RE: Re-Notification of Conditional Preliminary Approval, Lester Short Plat, File Number SP-07-44

RE: Lester Short Plat, File Number SP-07-44

DRAWN BY: M.M. SCALE: 1" = 100'
CHECKED BY: D.S.G. DATE: 11-01-06
PROJECT NO. 06208 SHEET 1 OF 2
PARCEL NO. 18-19-12000-0004

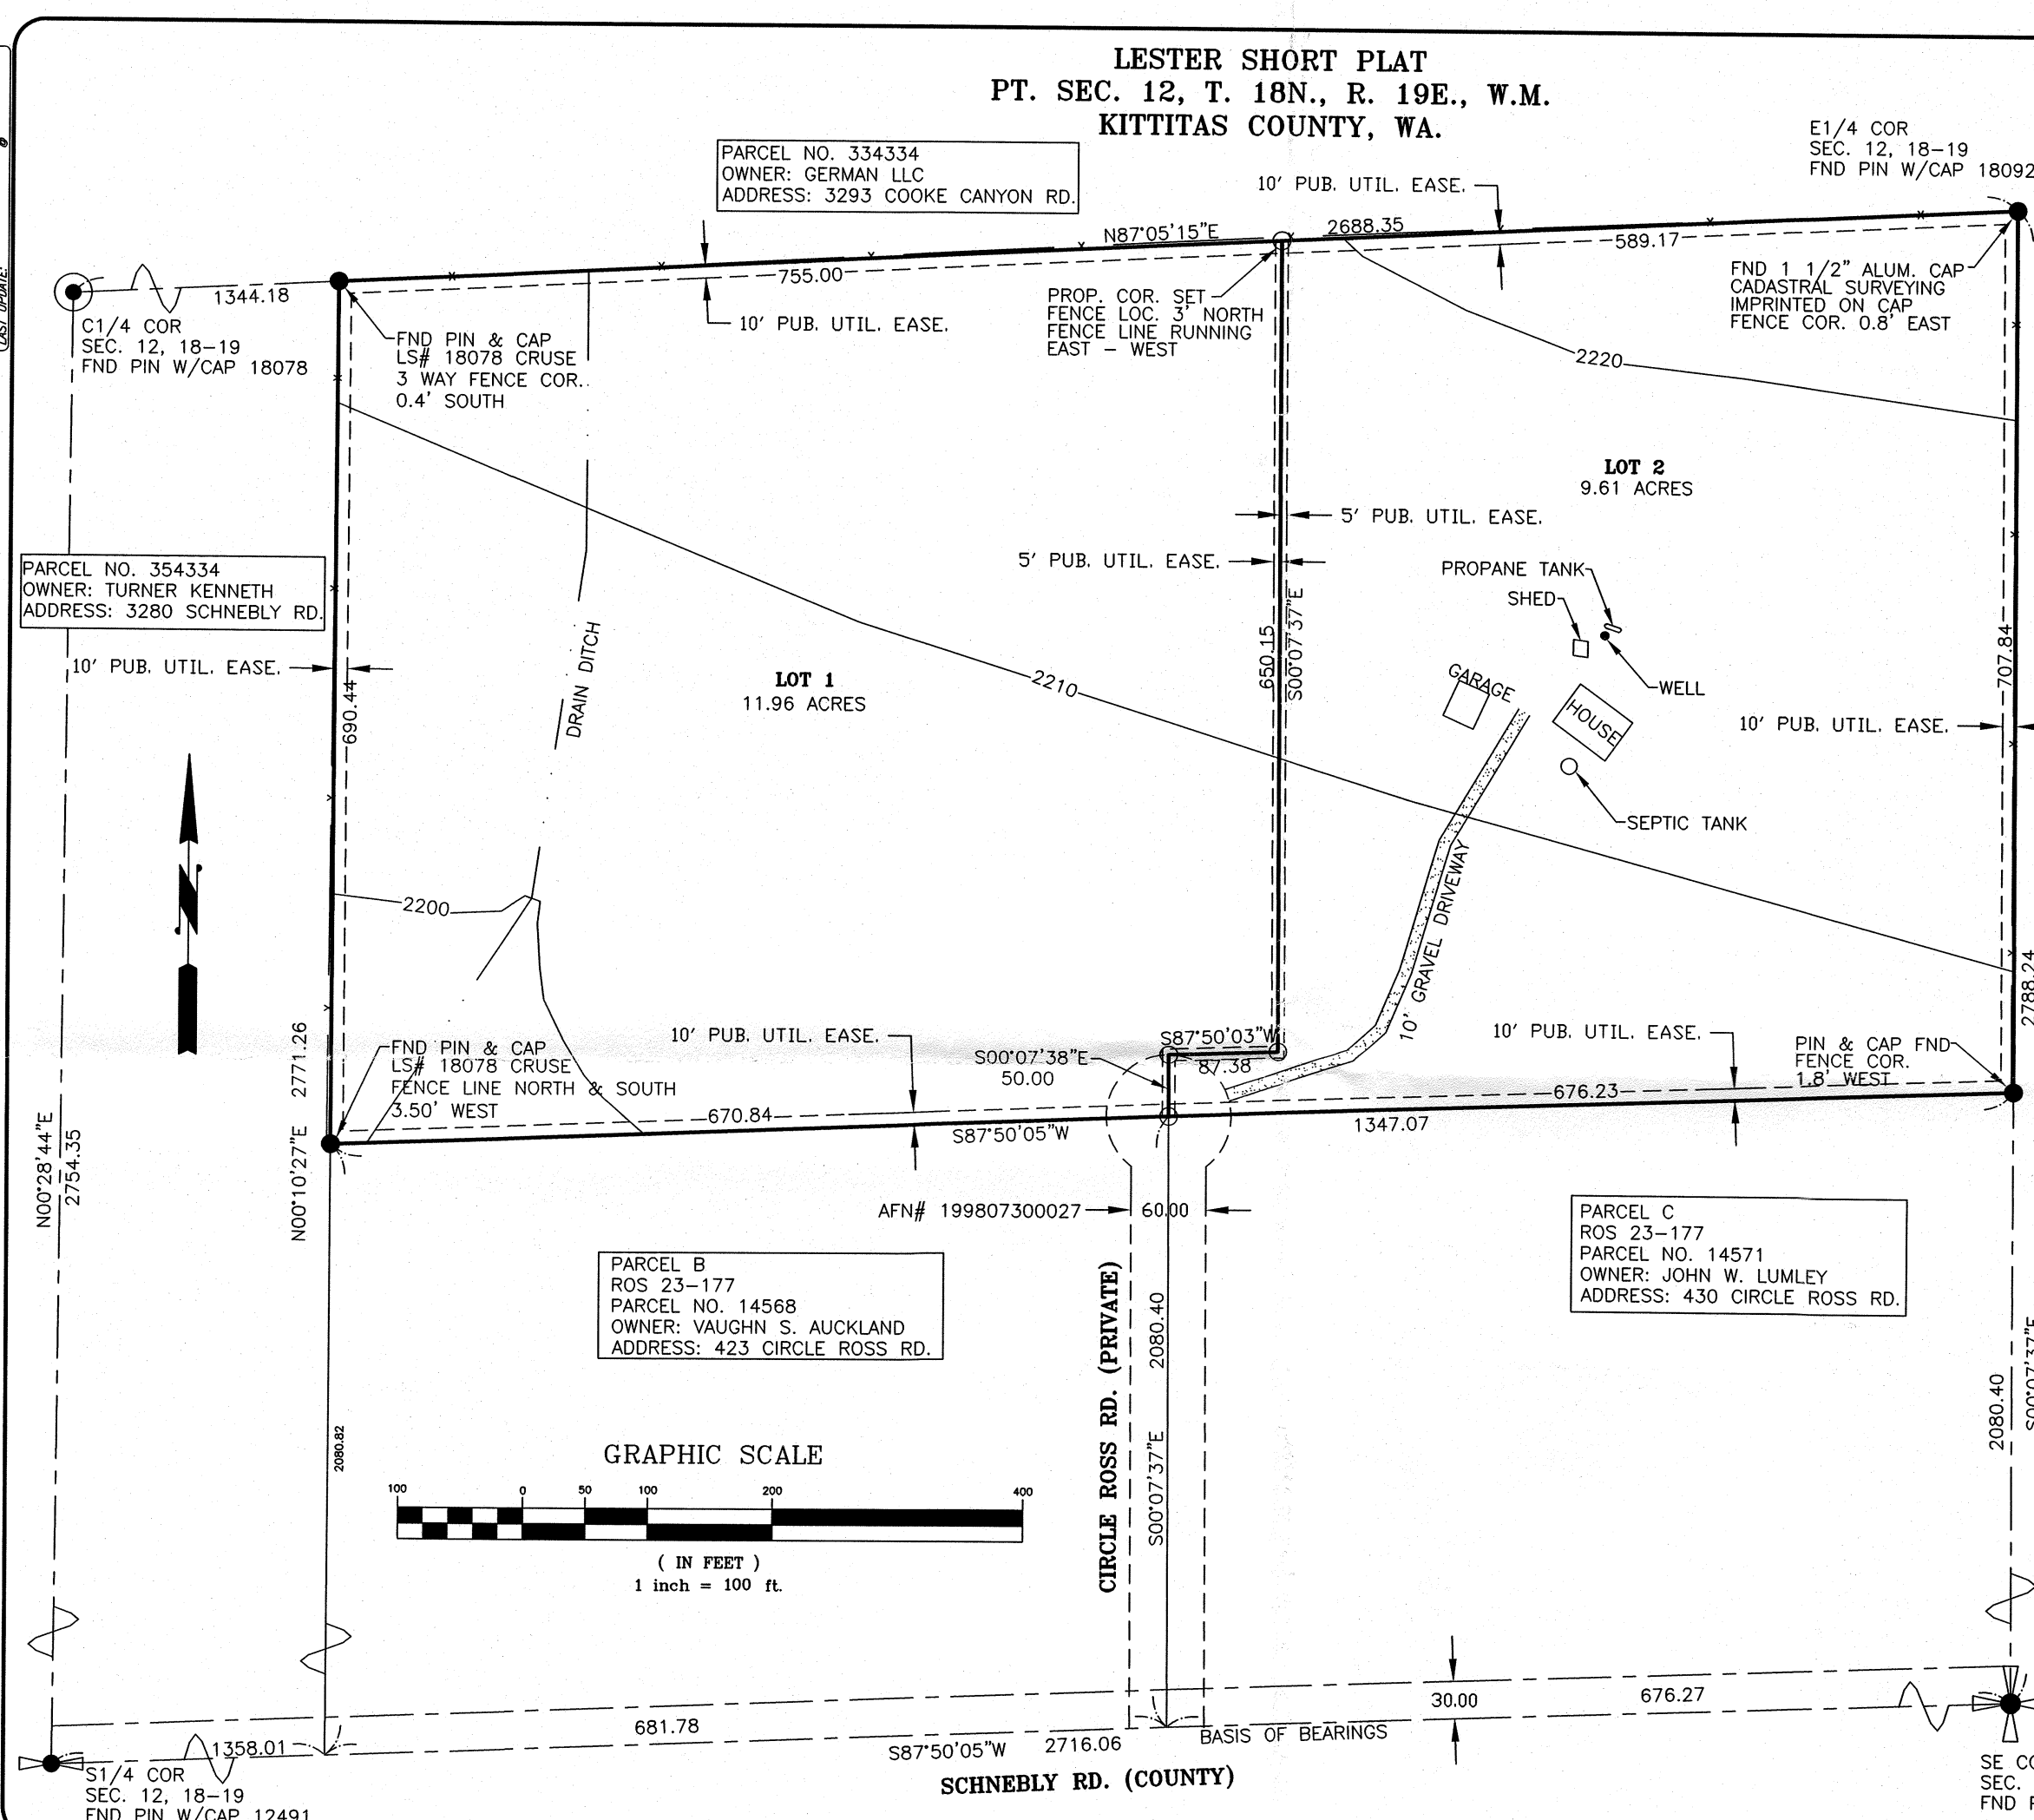
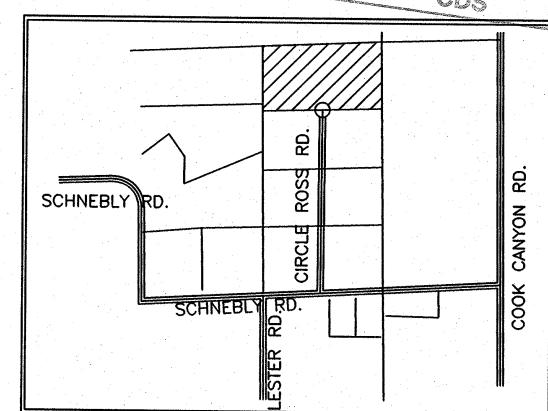
- 2) The road mislabeled as "Cook Rd." in the vicinity map on the first page of the plat drawings shall be changed to reflect the correct name of the road, which is "Lester Rd."

- 3) Critical Areas: Lot 1 of the Lester Short Plat has a PEMC wetland (Palustrine Emergent Seasonal) located on the southeast portion of the lot. The final mylars shall reflect the location of this wetland, and a statement on the plat shall read as follows:

- 4) The first page of the final mylars shall display a labeled space in the upper right hand corner in which to record the Receiving Number of the Short Plat.

- 5) In the Signature block reserved for the Kittitas County Public Works Department on the first page of the Short Plat drawings, the phrase "Kittitas County Public Works" which is currently displayed beneath the signature line shall be changed to read "Kittitas County Engineer".

- 8) The property owner's name shall be clearly labeled on the first page of the final plat drawings.
- 9) Plat notes employing the following phrasing and providing the required information (highlighted here in bold font) shall be present on the second sheet of the plat drawings in the portion labeled "Notes":
